# **OXFORDSHIRE COUNTY COUNCIL'S RESPONSE TO CONSULTATION ON THE FOLLOWING DEVELOPMENT PROPOSAL**

**Application no:** 21/01123/F

**Proposal:** Demolition of existing buildings. Construction of replacement business units and associated external works. (Re-submission of 20/01127/F)

**Location:** Hatch End Old Poultry Farm, Steeple Aston Road, Middle Aston

DRAWING TITLE	- Proposed Site Plan - Overall		
CONTRACT	- The Hatchery		
MODELLED BY	- HS	ISSUE DATE	- 10.09.21
CONTRACT NO	- JOB139990	SCALE	- 1:500 @A1
DRAWING No	- 139990_P102	REVISION No.	E

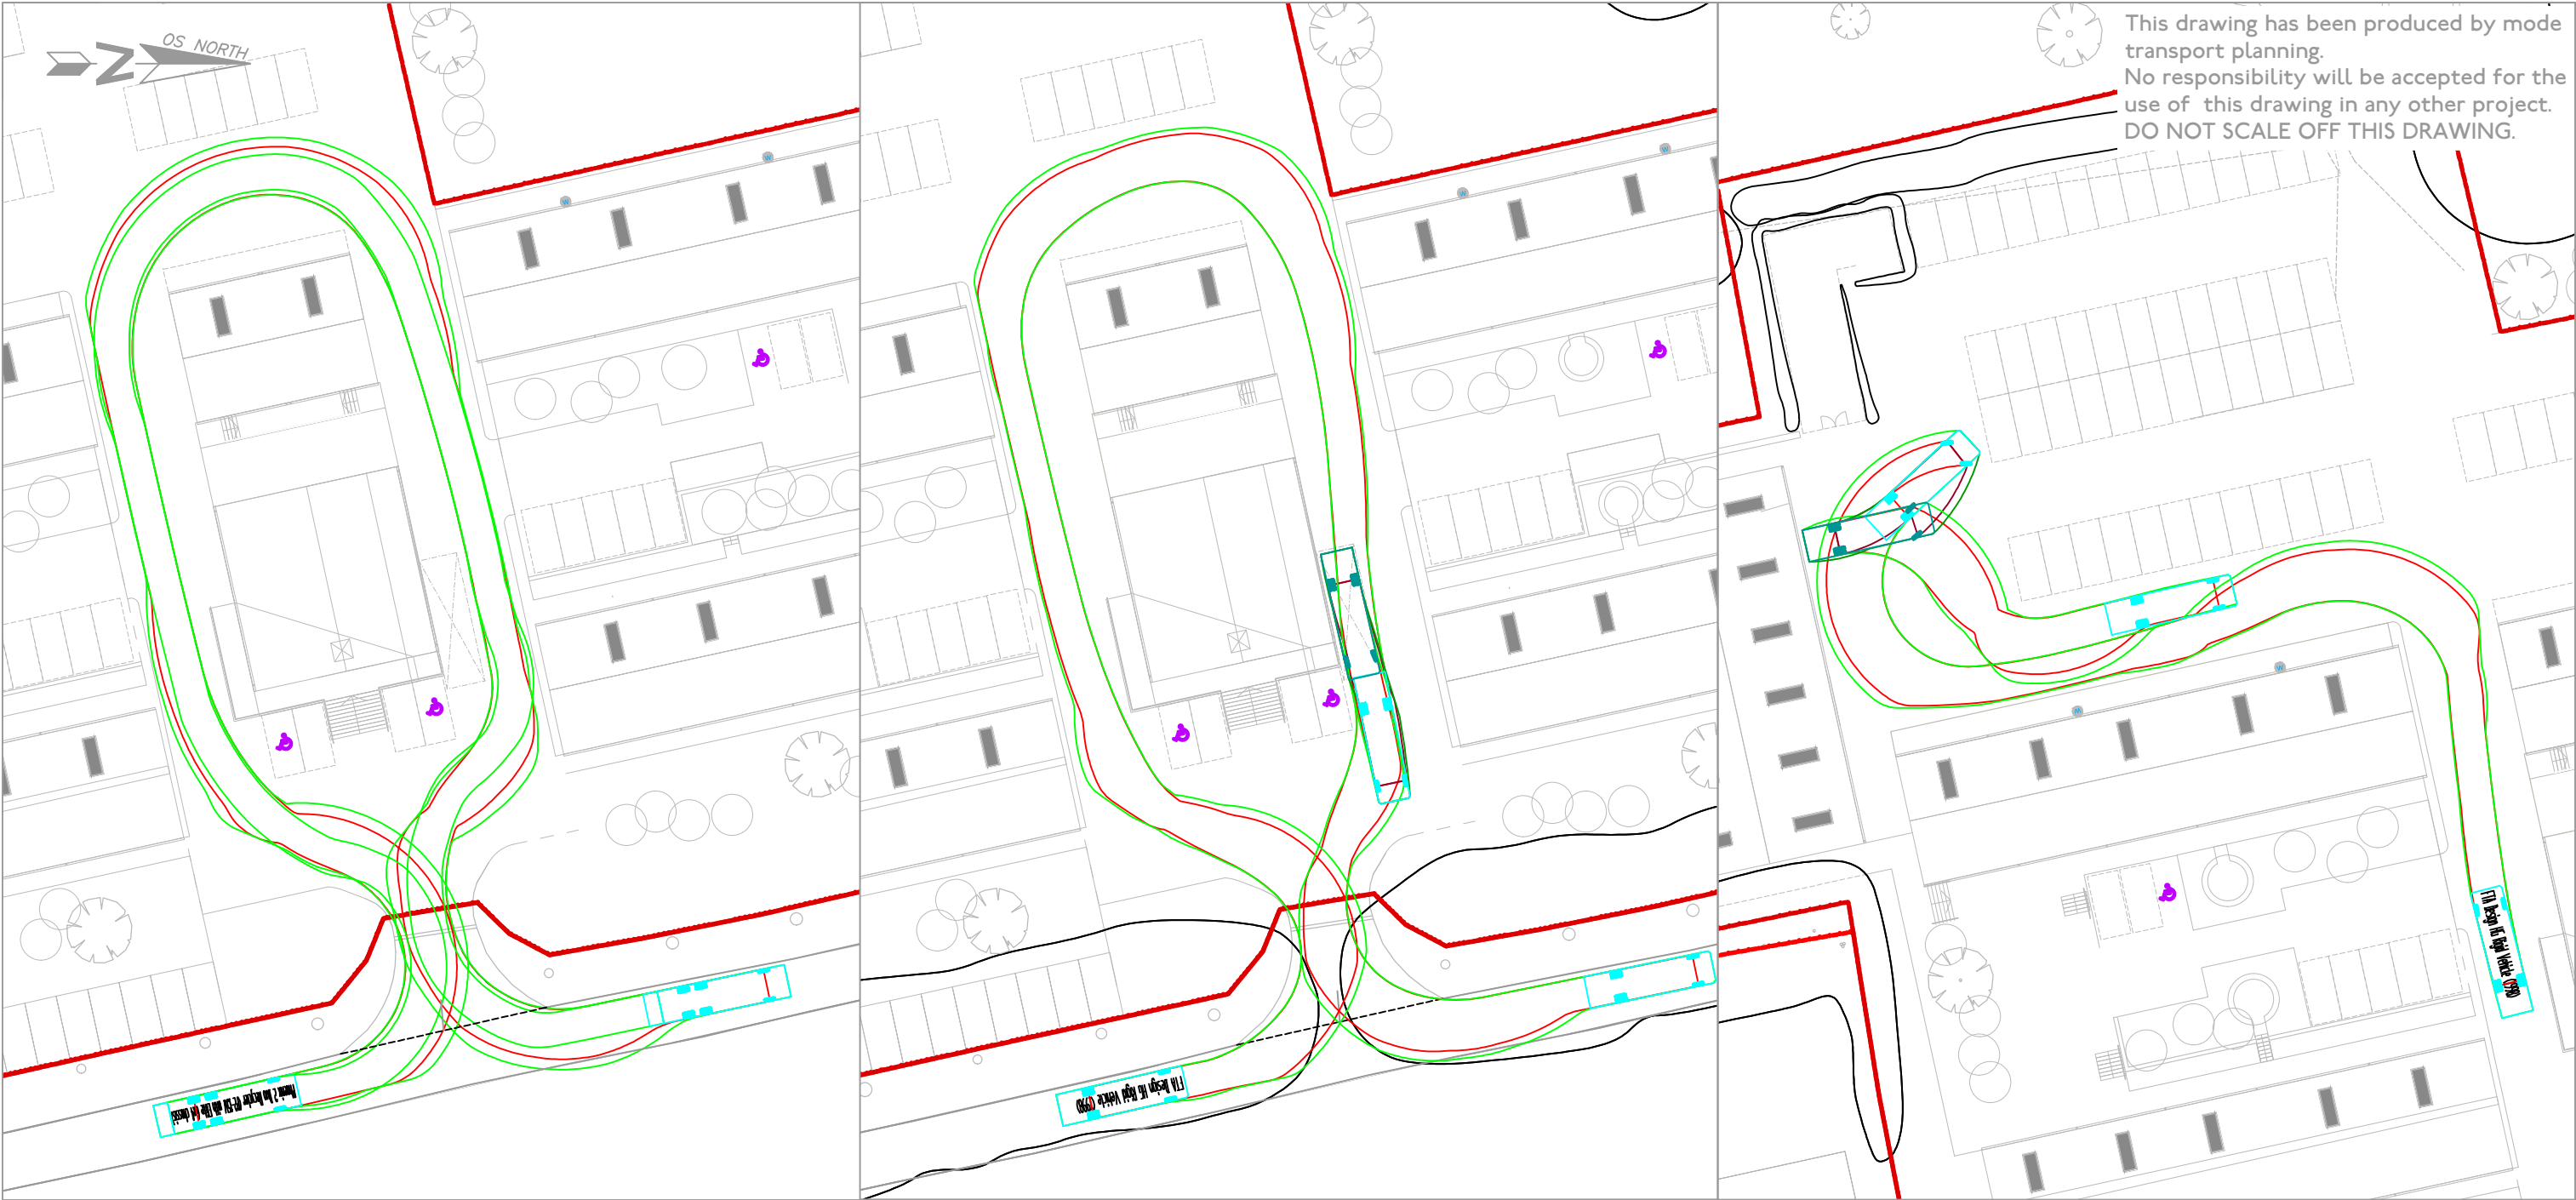
Regardless of the above, the County has already indicated that an internal pedestrian connection to a public footpath which borders the western boundary of the site and connects with Fir Lane will provide a suitable pedestrian route between the site and Steeple Aston to the south. However, the County would take this opportunity to specify that the internal pedestrian connection should be accompanied by improvement works to the surfacing of the public footpath to which it connects.
